Ribble Valley Borough Council  
Council Offices  
Church Walk,  
Clitheroe  
Lancashire  
BB7 2RA

Phone: 0300 123 6780  
Email: [Kathryn.Walsh@lancashire.gov.uk](mailto:Kathryn.Walsh@lancashire.gov.uk)  
Your ref: 3/2025/0045  
Our ref: 3/2025/0045/HDC/KW  
Date: 26 February 2025

**Location:** Little Daub Hall Parsonage Lane Chipping PR3 2GJ  
**Proposal:** Proposed demolition of lean-to side and rear extensions to be replaced with lean-to side extension and rear lean-to canopy including alteration to vehicular access and parking.  
**Grid Ref:** 361422 442628

Proposed and Existing
Block Plans
DATE 10.10.2024

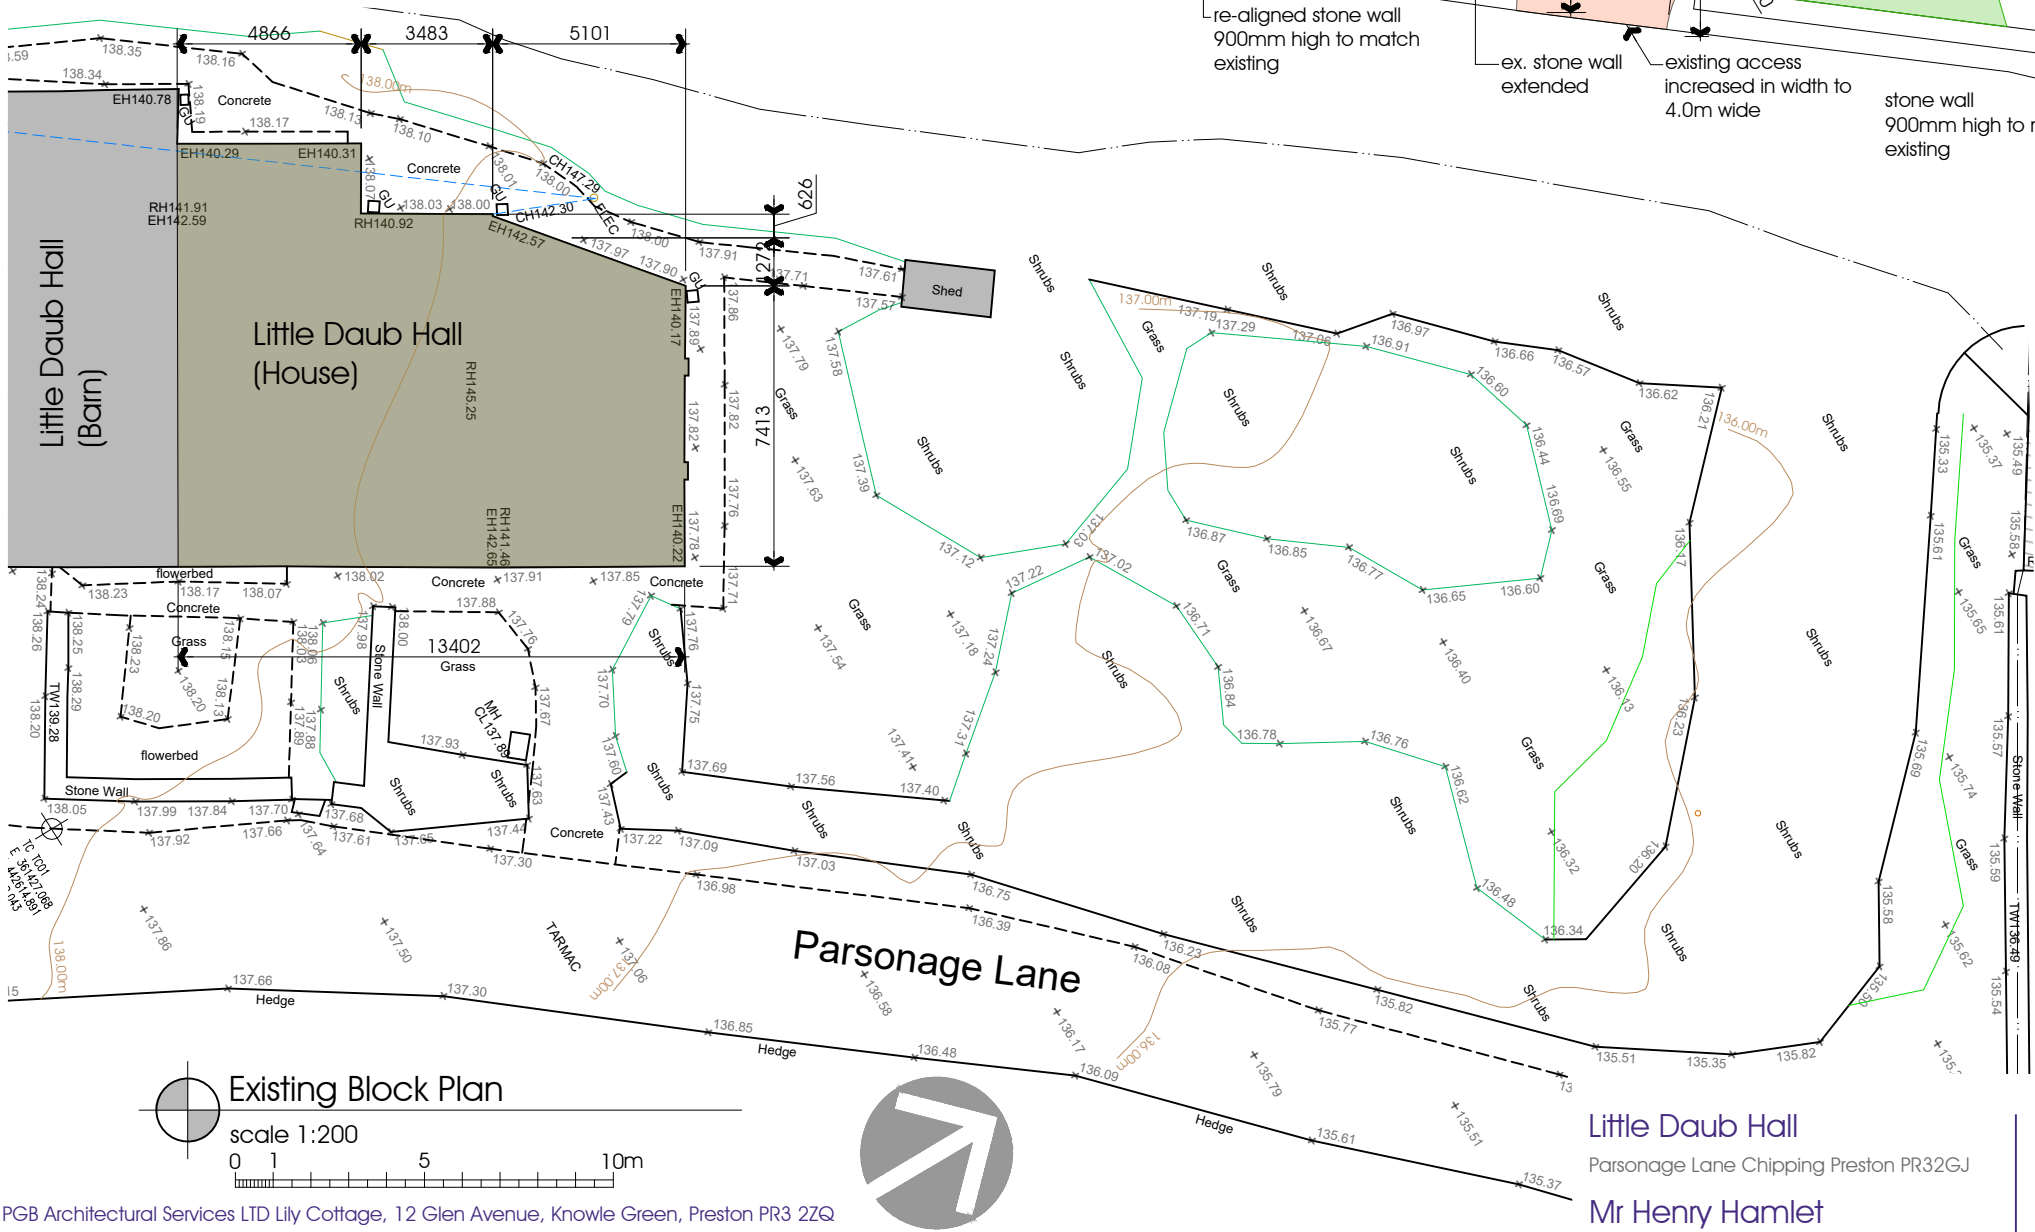
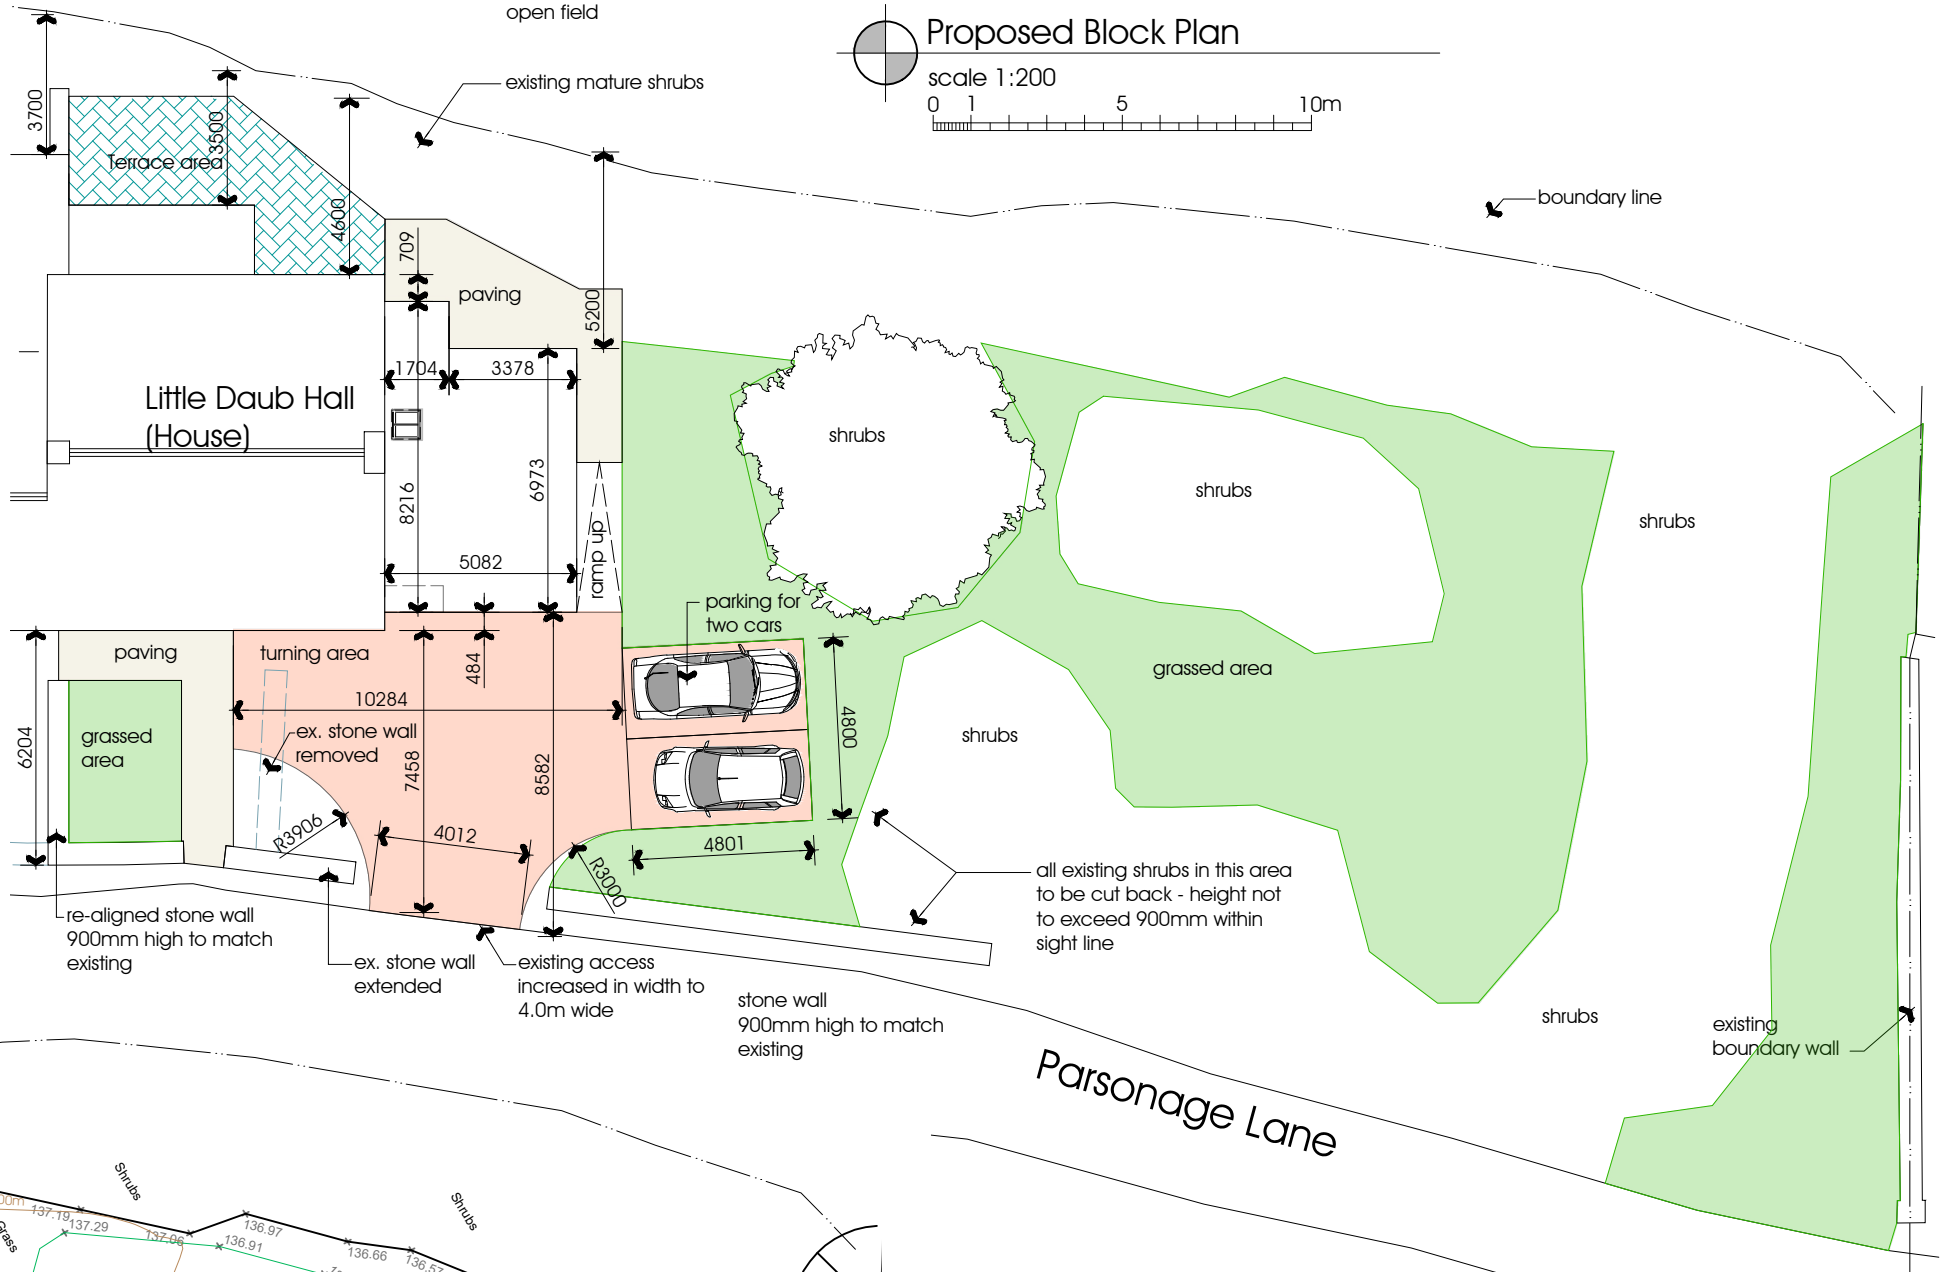
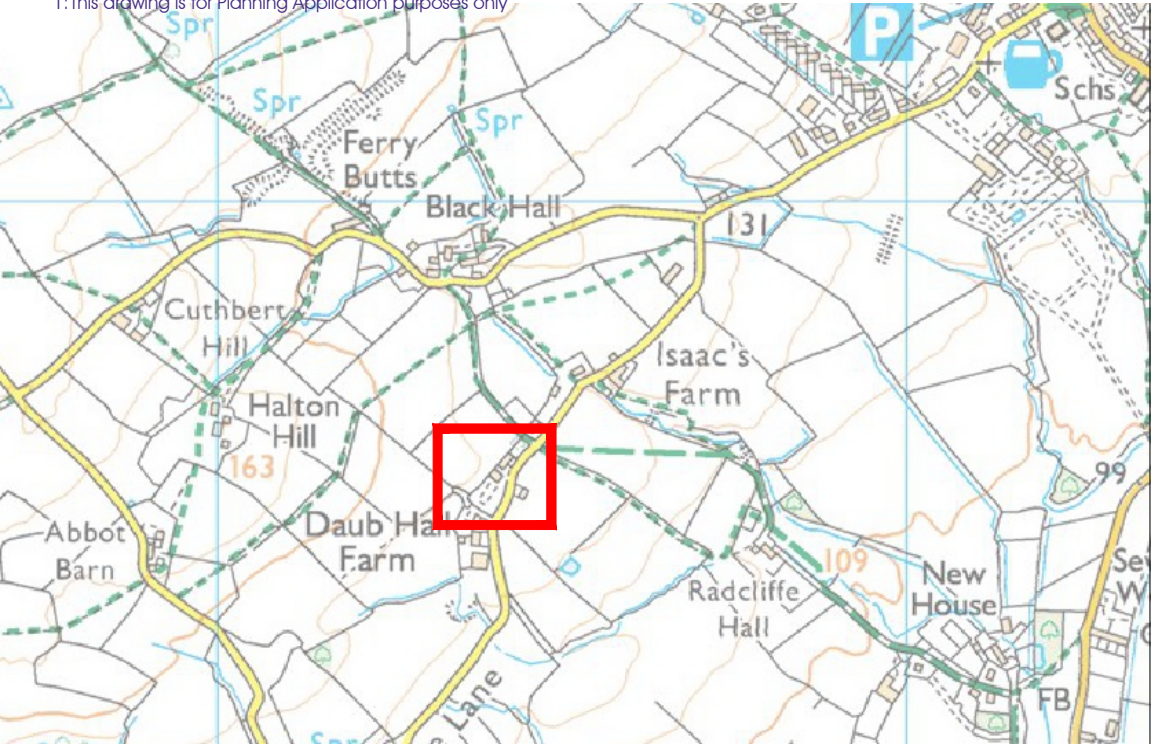
The proposal will extend the existing access from Parsonage Lane, which is an unclassified road subject to a national speed limit. The submitted drawing number 014 Rev A, titled Proposed and Existing Block Plans indicates that an extended vehicle access is proposed. This is acceptable to Lancashire County Council's Highways, the extended vehicle crossing within the adopted highway will need to be constructed under a section 171 agreement of the Highways Act 1980.

The LHA has reviewed drawing number 014 Revision A, titled Proposed and Existing Block Plans and noted the parking spaces meet the LHA's parking standards. The addition of turning provisions will allow vehicles to enter and exit the site in a forward gear.

Before the widened parking area is used for vehicular purposes, it shall be appropriately paved in tarmac, concrete, block paving, or other hard material to prevent loose surface material from being carried on to the public highway.
